2 June 2020

RE: SSD – 6693-mod-1 – Tip Height Increase - Rye Park Wind Farm

Hilltops Council wish to make the following submission on the above-mentioned modification, currently on public exhibition, closing 3 June 2020.

C.5 OVER-DIMENSIONAL AND HEAVY VEHICLE ACCESS ROUTES

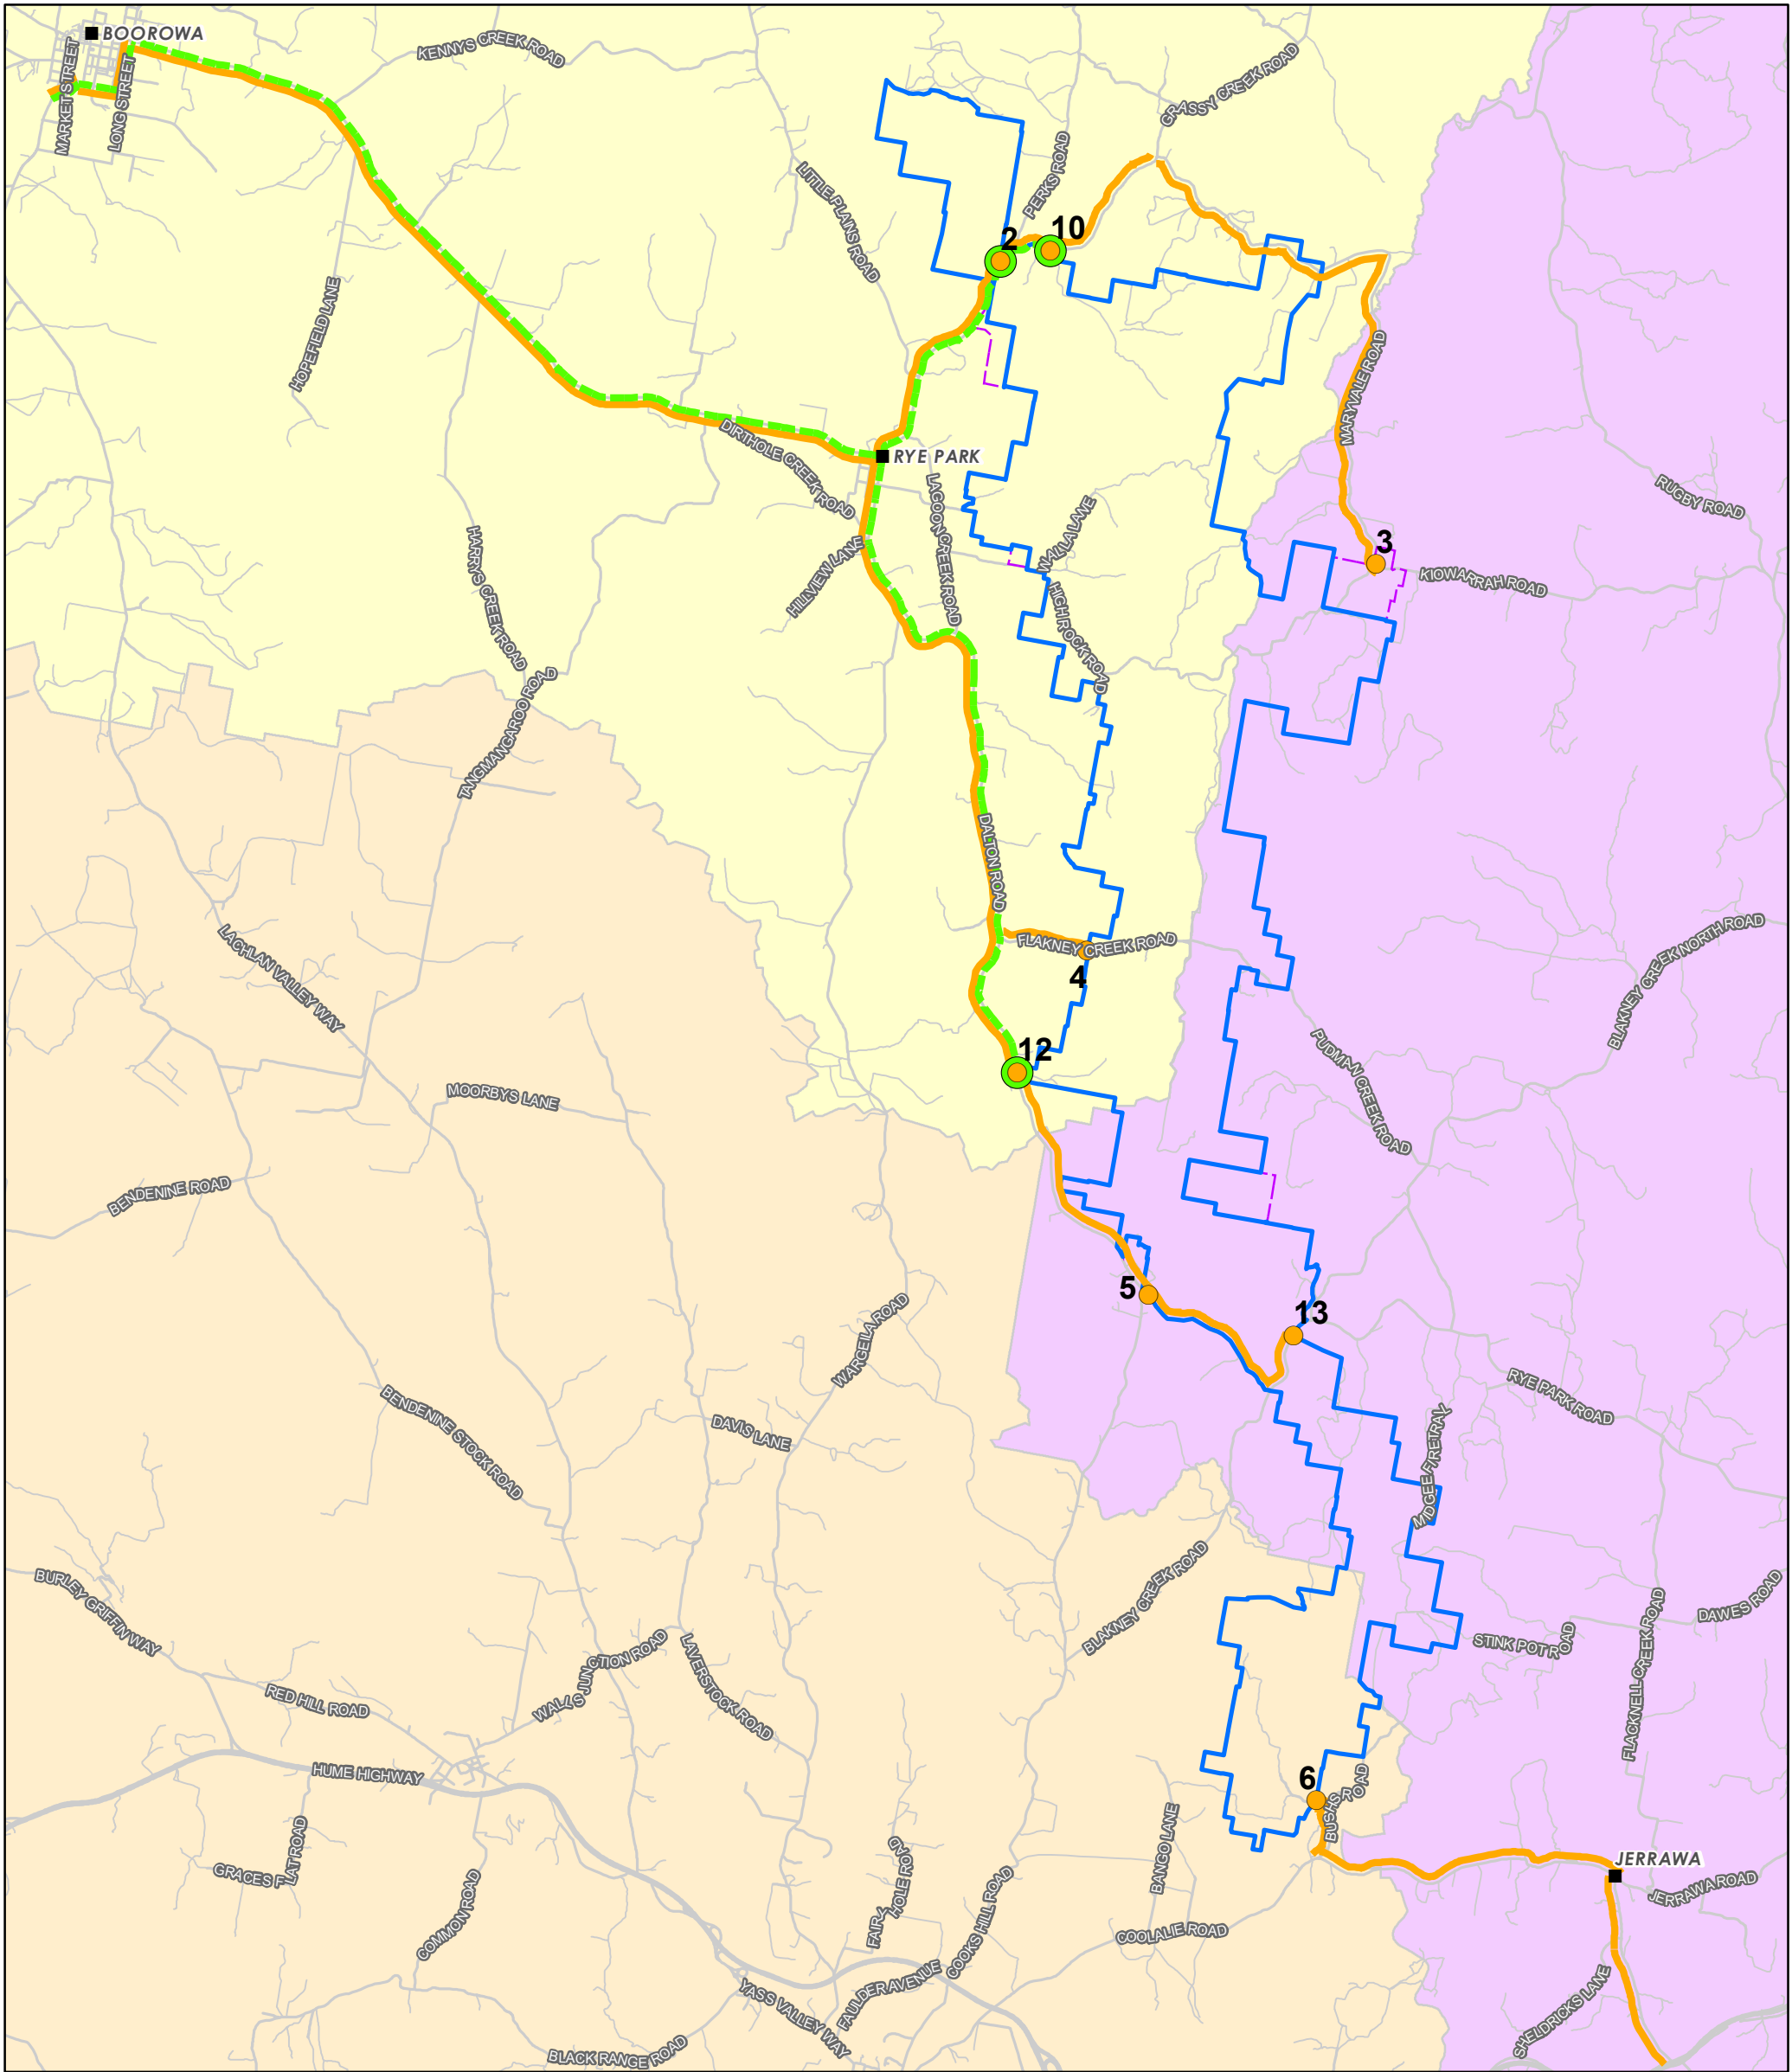
Council has major concerns with the routes identified, particularly in and around the townships of Boorowa and Rye Park. Council has received several enquiries from concerned residents about the routes being considered in this modification, and Council would express these same concerns.

When entering the township of Boorowa, Council has a preference for the route to exit Lachlan Valley way onto Meads Lane then head along Long Street to reach Rye Park Road. This would remove the requirement for travel down Trucking Yard Road and Dillion Street.

The Rye Park main street is of concern as many houses are built in close proximity to the roadway with minimal setbacks. In addition, there is little ability to widen the pavement due to roadside drainage constraints. The noise and vibration of vehicular movements is also not preferable within the townships due to potential impacts on schools, local businesses, and other local traffic movement.

As a by-pass option to the township of Rye Park, Council prefers the use of Dirt Hole Creek Road. This road is a 3m gravel road and would be expected to have the same pavement upgrade as a 7m formation and seal.
